**From:** DataSpace Consult [dev.admin@resolutiondm.com]  
**Sent:** 29 September 2009 10:31  
**To:** Planning  
**Subject:** Comments Added: 21 TOLMERS AVENUE, CUFFLEY

Application Details:  
Application ID: S6/2009/1940/FP - Mr P Jefcoate Application Owner: Welwyn & Hatfield Borough Council (Development Control Officer)  
Applicant: MR D BARKER  
Location: 21 TOLMERS AVENUE, CUFFLEY  
Deadline Date: 19/10/2009 16:53:19  
Description: ERECTION OF FRONT AND REAR TWO STOREY EXTENSIONS PART TWO STOREY STEPPED SIDE EXTENSION, BASEMENT TO FRONT AND ADDITION OF ROOF SPACE

Comment Added:  
Document: Existing Plans and Elevations.pdf Document Description: .<br>File:Existing Plans and Elevations.pdf<br> (from Zip file - S6-2009-1940-FP.zip.zip)

STREET SCENE
 AND ELEVATIONS
 PROPOSED

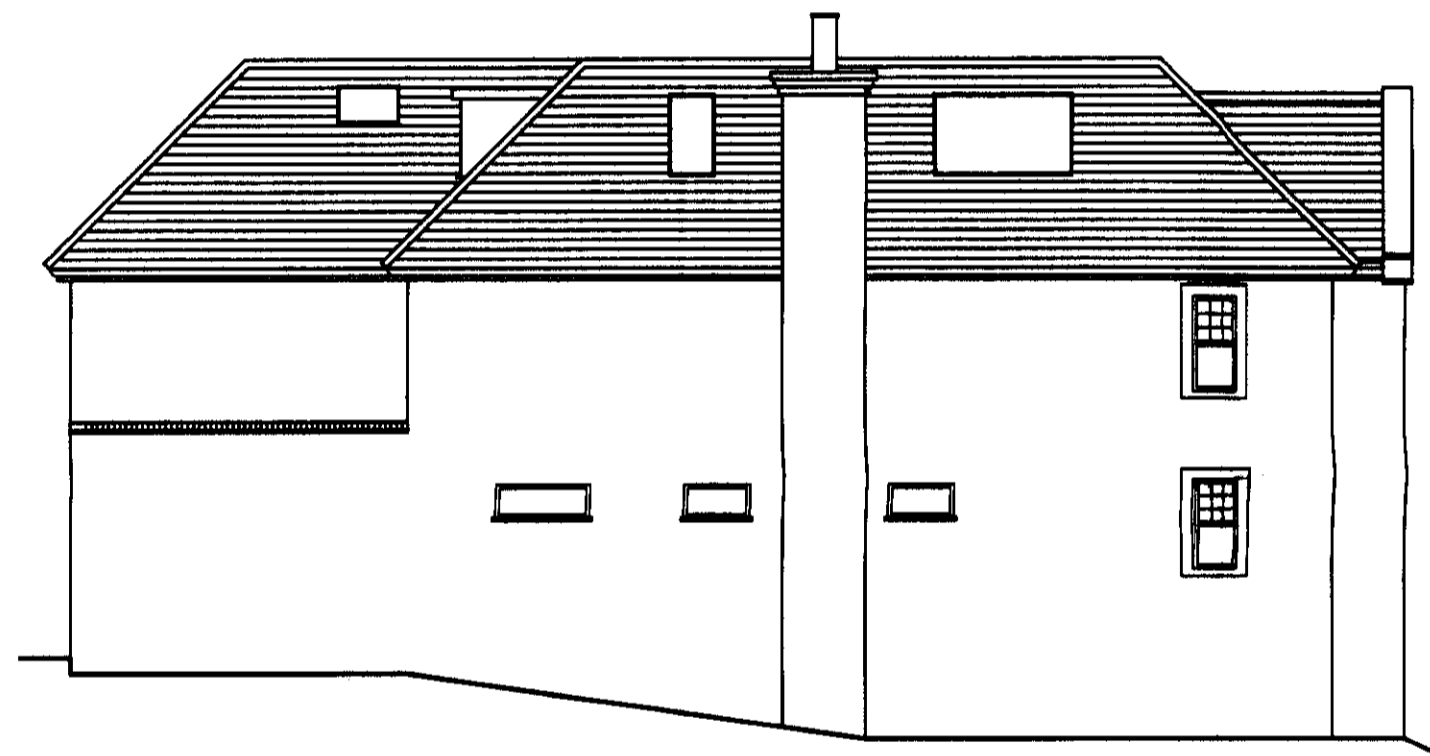
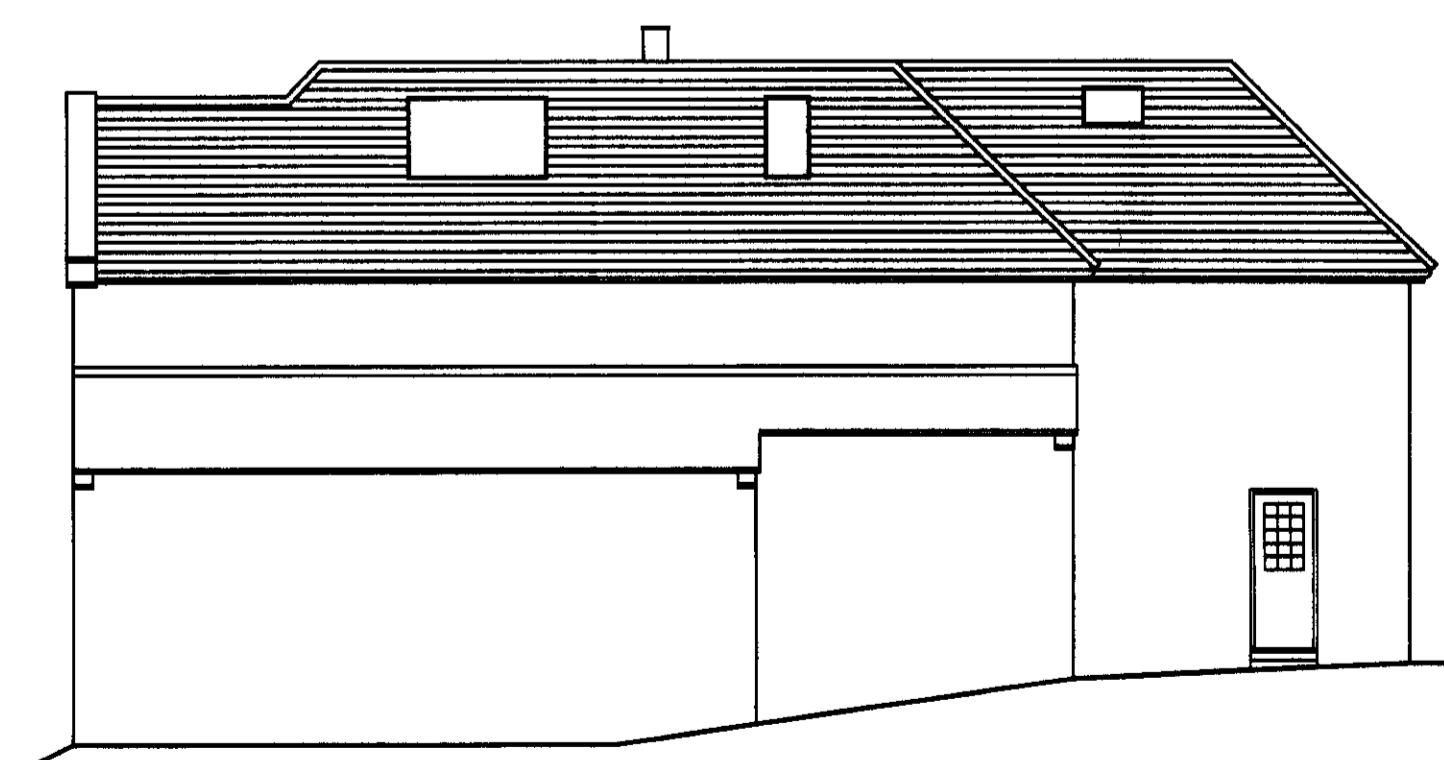
Commented By: info@northawcuffleyparishcouncil.gov.uk  
Comment: The PC feel this is an overdevelopoement of the site. The roof height appears to be raised and the building will become 4 stories if a basement and roof rooms are permitted. Will overlook neighbour lower down hill.
